Application No: R/116/21/HH
Site Address: 17 Mill Close Rustington BN16 3HR
Description of works: Erection of single storey rear extension

Thank you for your internet representation made on 13th June 2021 which has been recorded as an objection with the comments as follows:

Plans & Elevations As Proposed

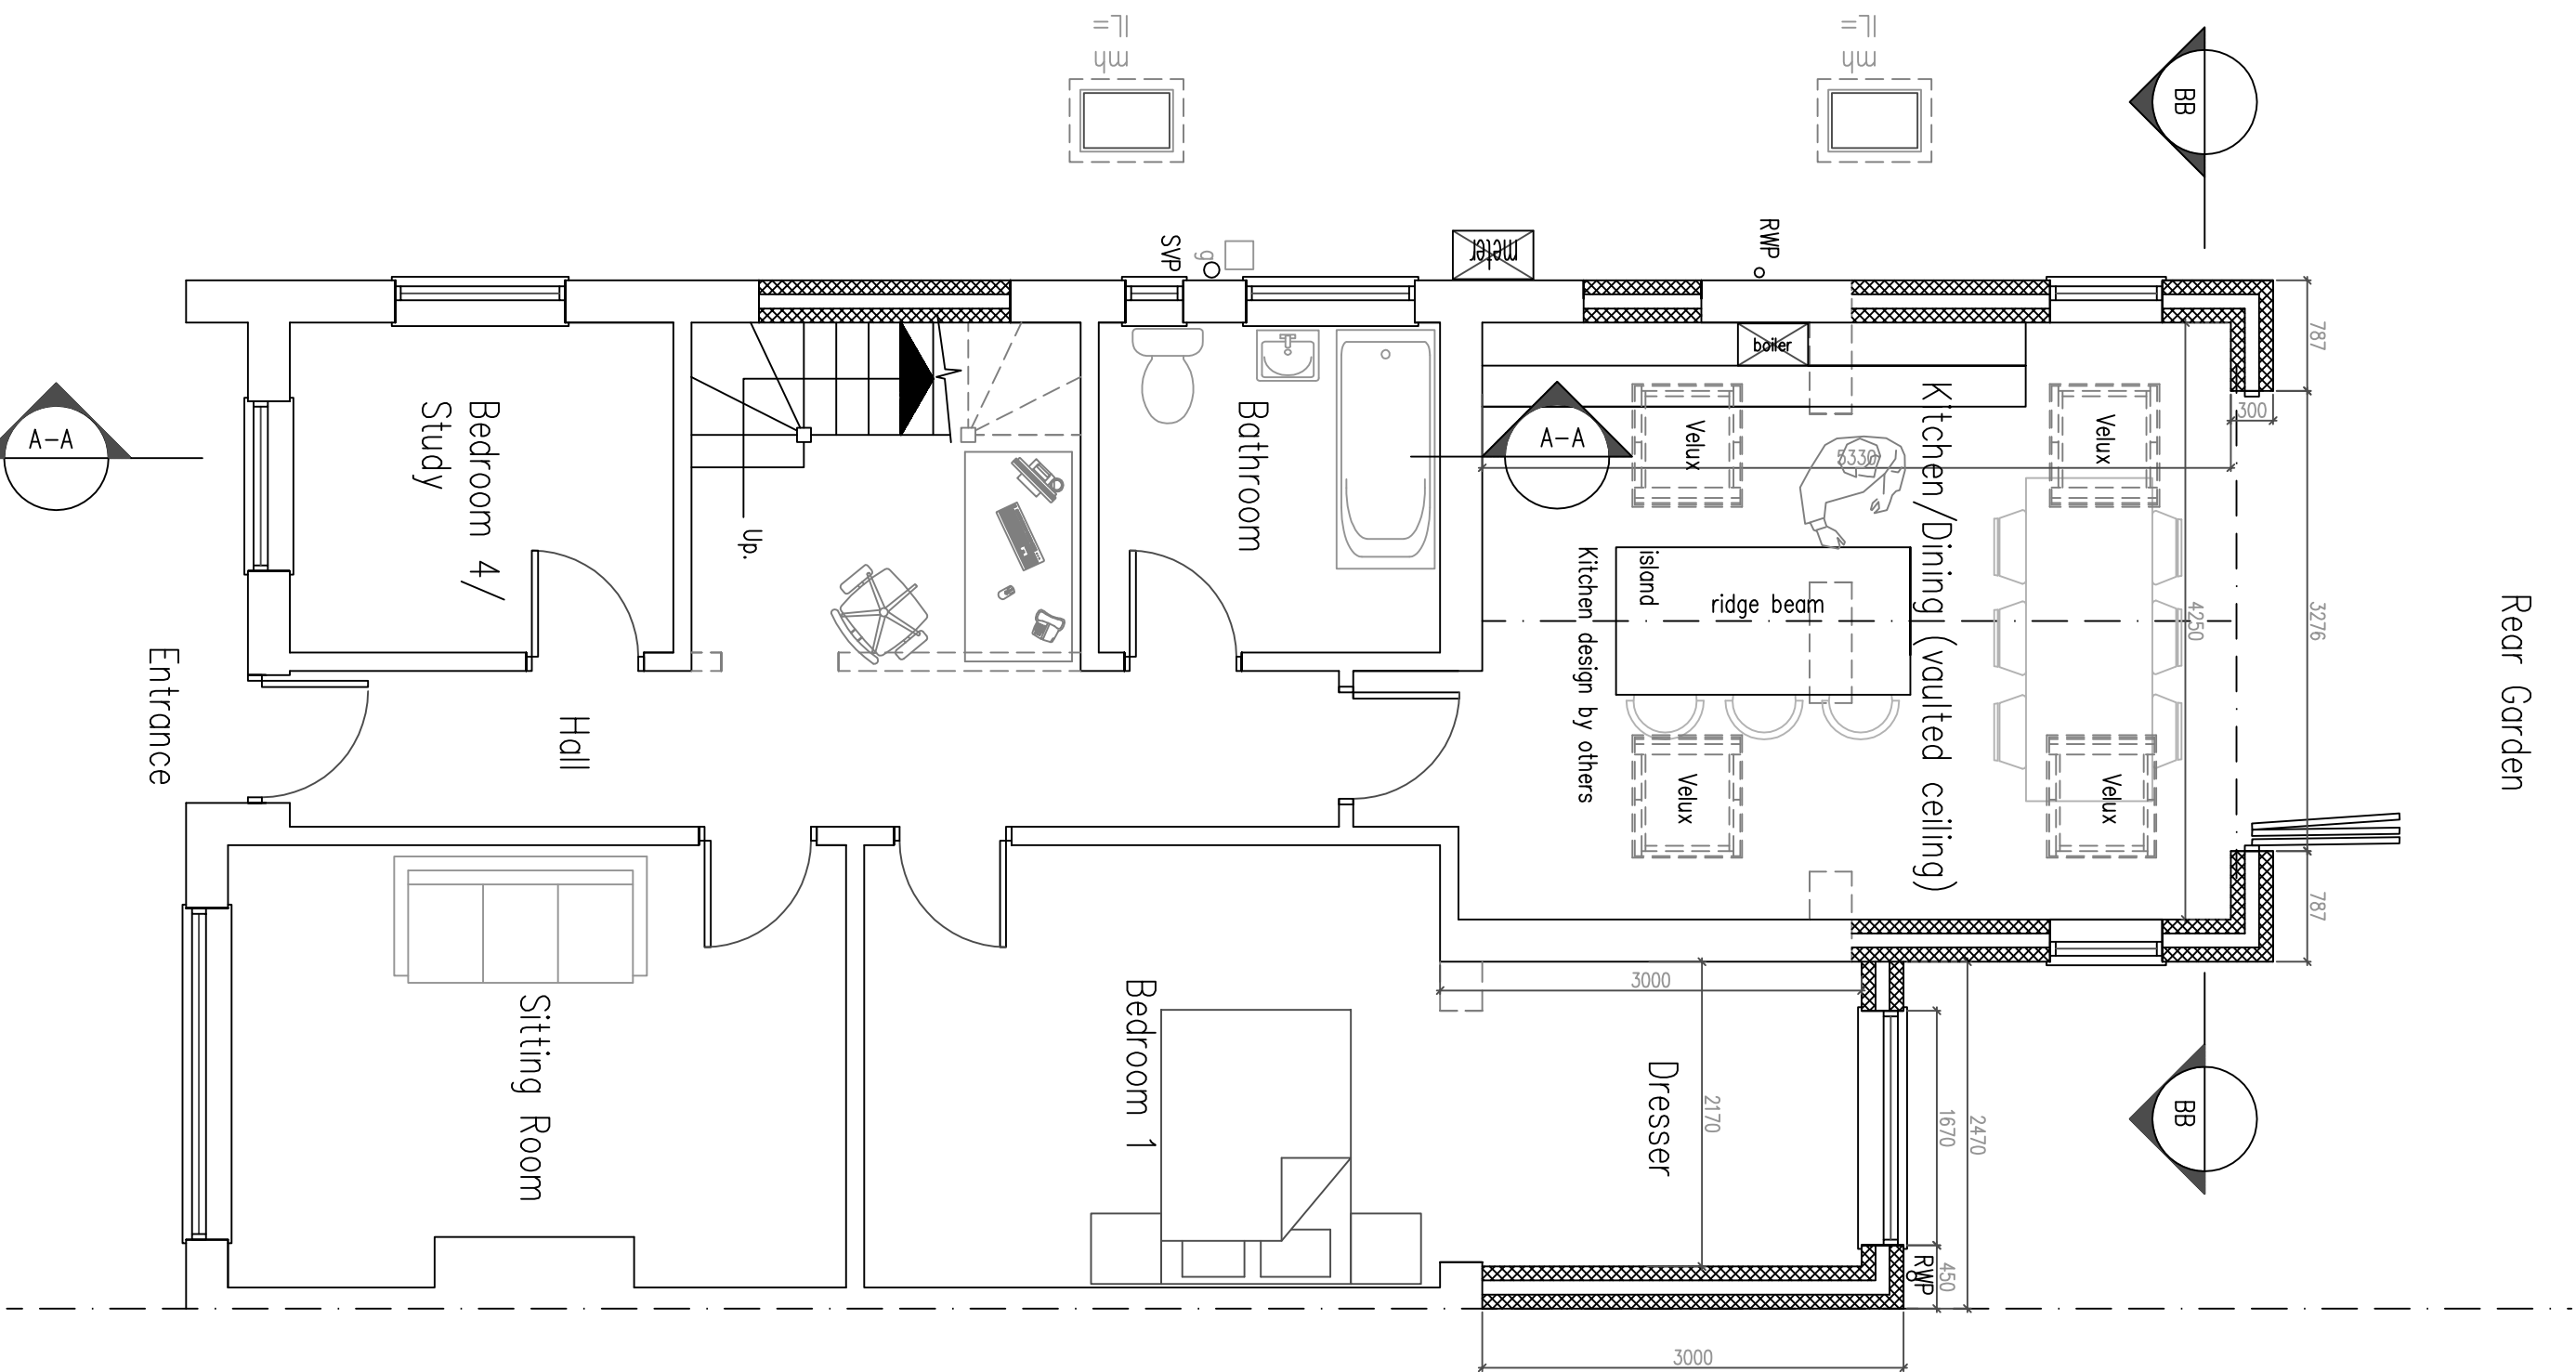
The above planning application is for a single storey extension, but details stairs, leading to very large roof extension, having 2 large Dormer windows, facing eastwards to our bungalow. As all of our living areas and rear garden, face to the west, the sheer size and height of this extension with the proposed windows would result in complete overlooking and complete loss of privacy in our living areas and garden.

As this application is for the single storey extension, it does not show the full details of the roof extension, but surely the Dormers would be better placed looking forwards down Mill Close, which would match the roof extension previously carried out by the adjoining semi and would rectify the problem of overlooking and loss of privacy in our property and garden.
